SF20/125654, DOC21/838853

RE: New Request for Advice – Response to Modification of SSD 8517 – Expand retail uses into Innovation Plaza Locomotive Workshops (MOD 7)

6 October 2021

Drawing Title
PROPOSED ELEVATIONS

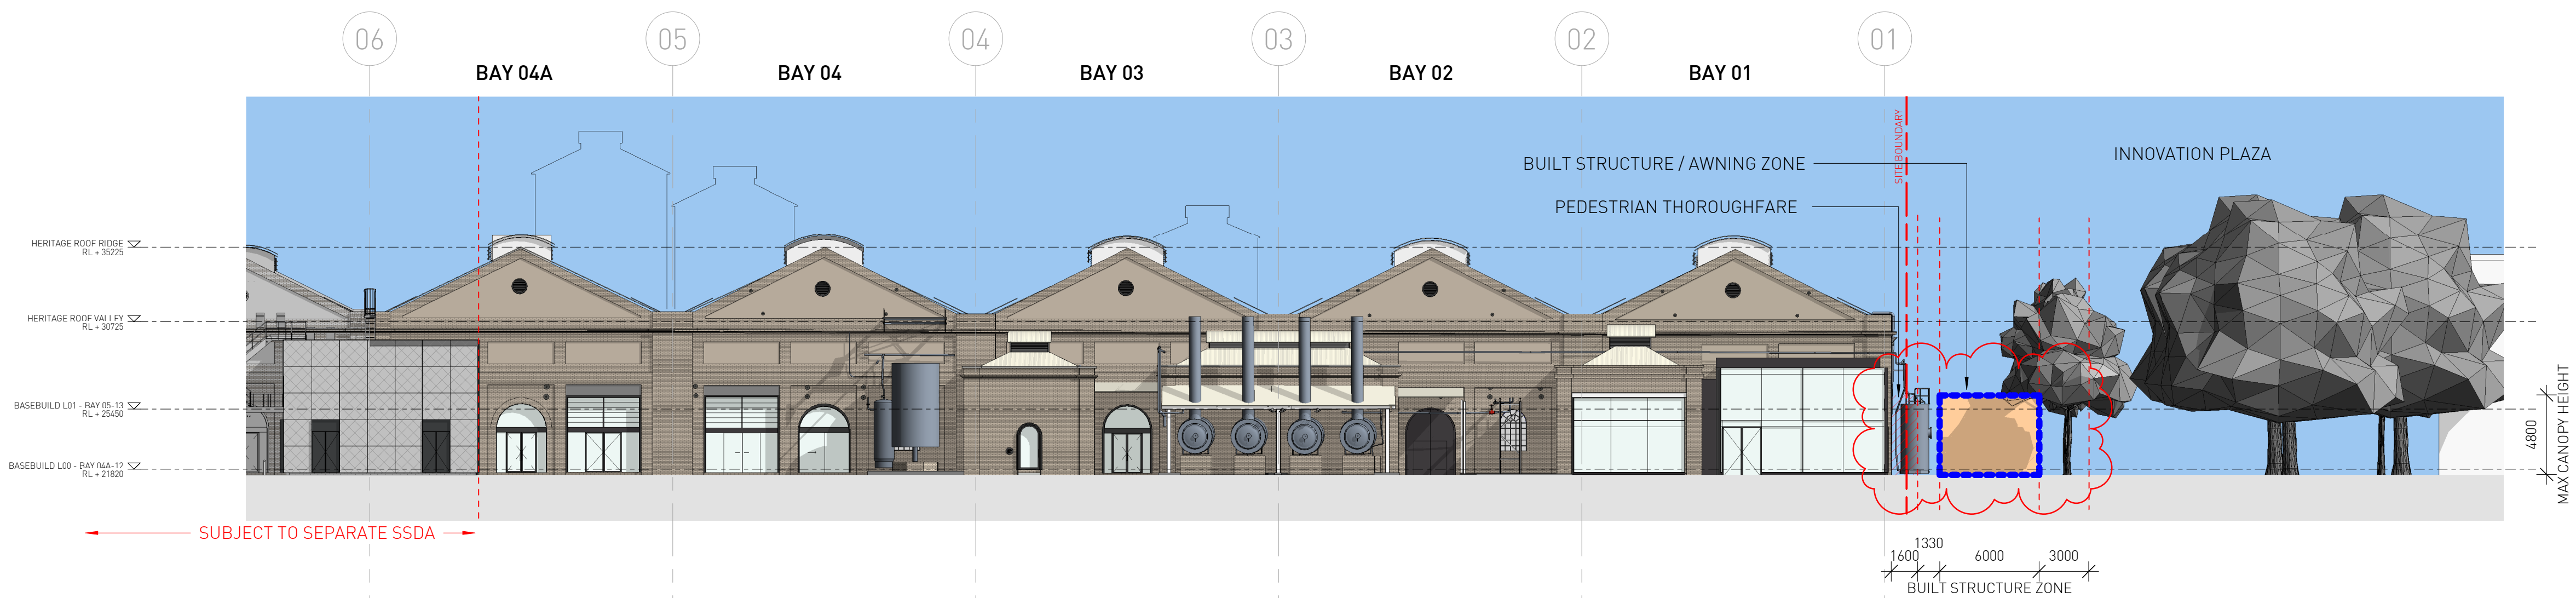
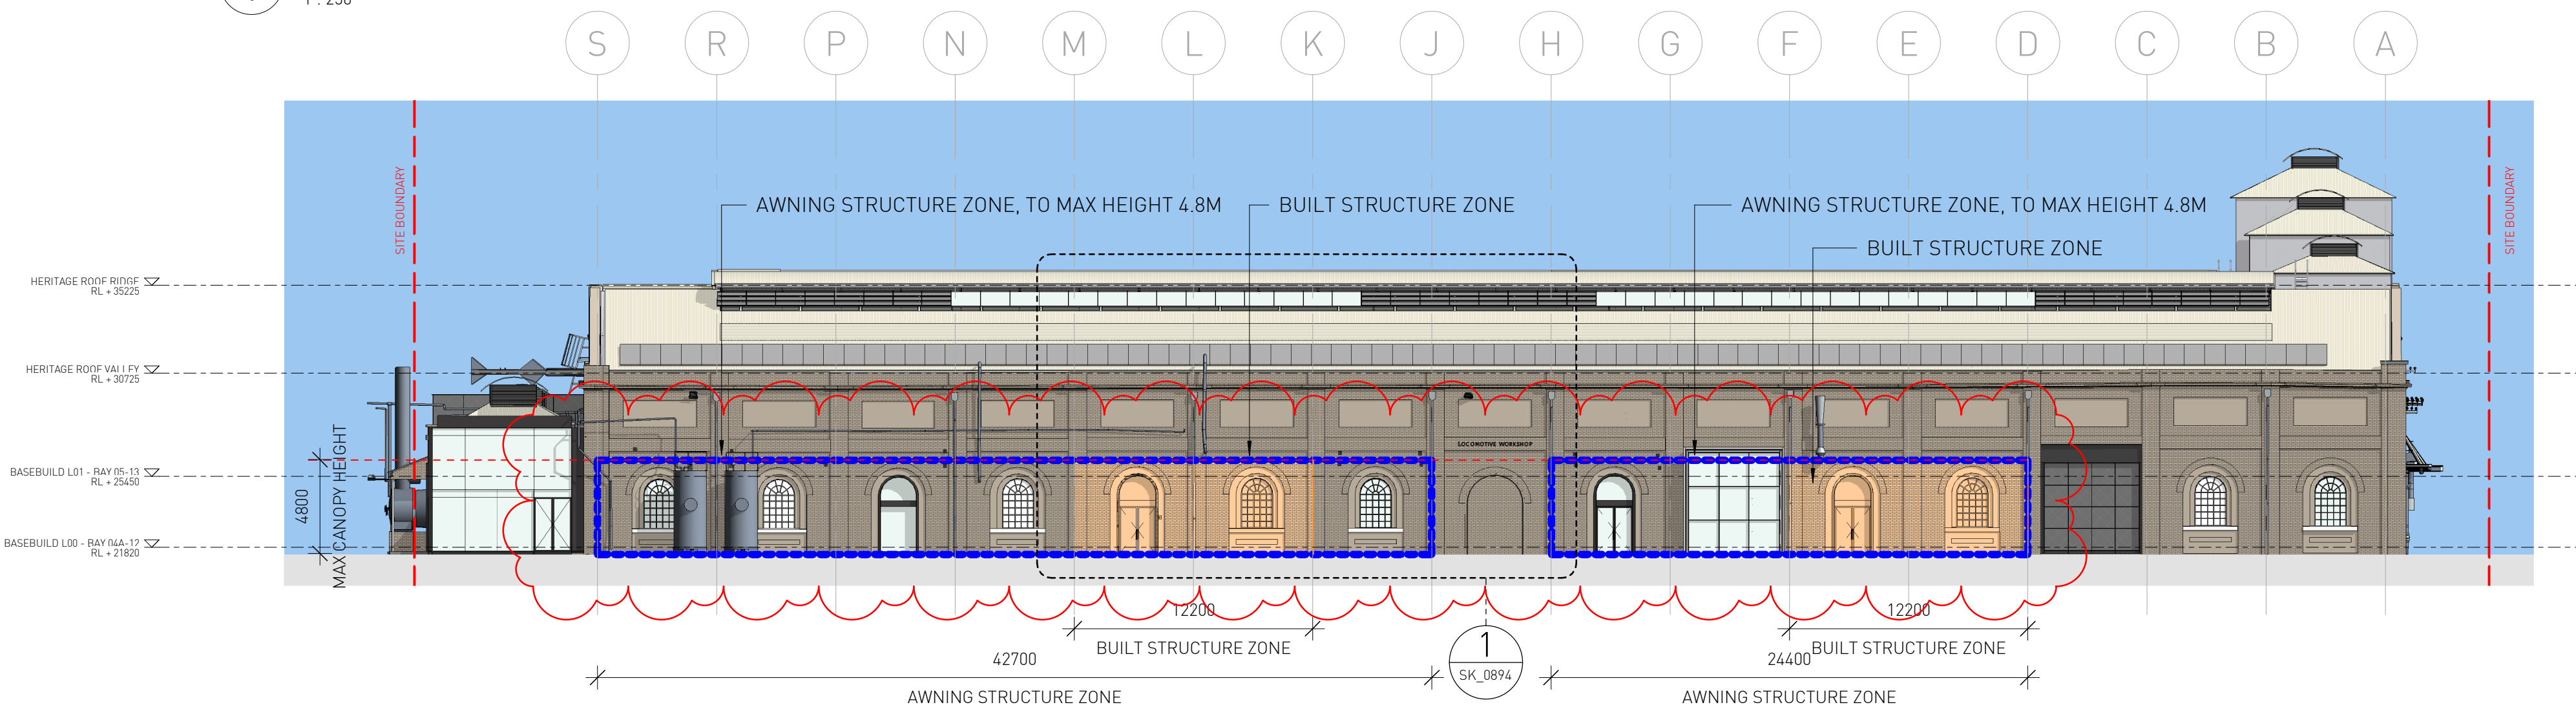
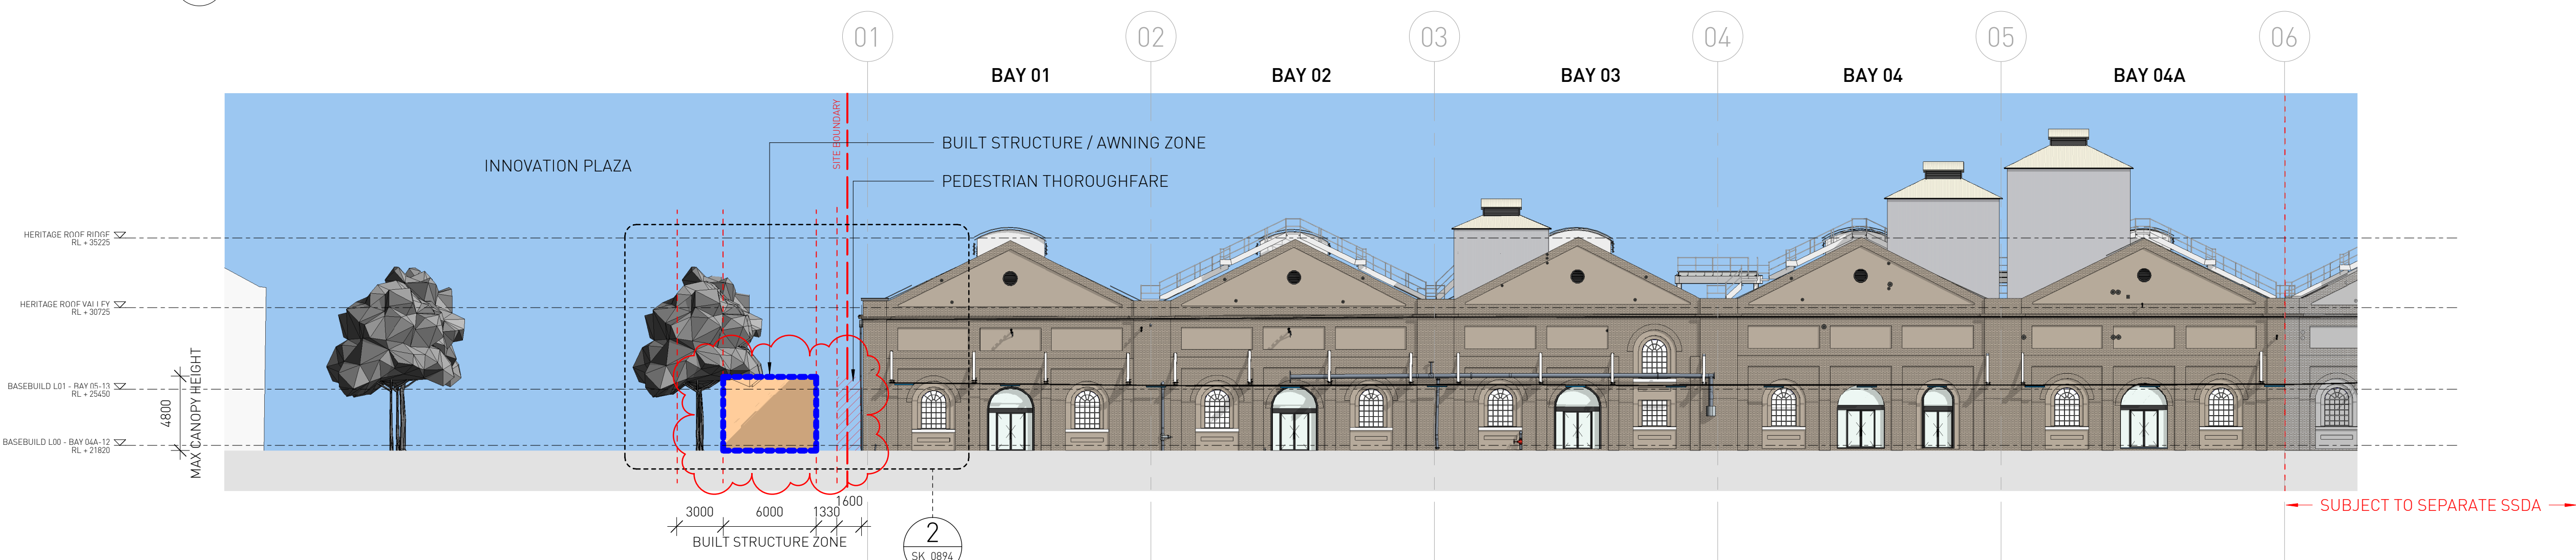
We also note the indicative built structure envelopes have been modified to remove the proposed northern built structure and substantially decrease the area of the southern built structure (73.2m² to 14m²).

We still have concerns with the permanence of the structure, particularly as the Response states that it will be sited in perpetuity. We therefore reiterate our previous advice that any structure must be temporary, portable, reversible and be responsive to a changing environment, to adjacent uses (existing and future) and to future strategies to activate the area.
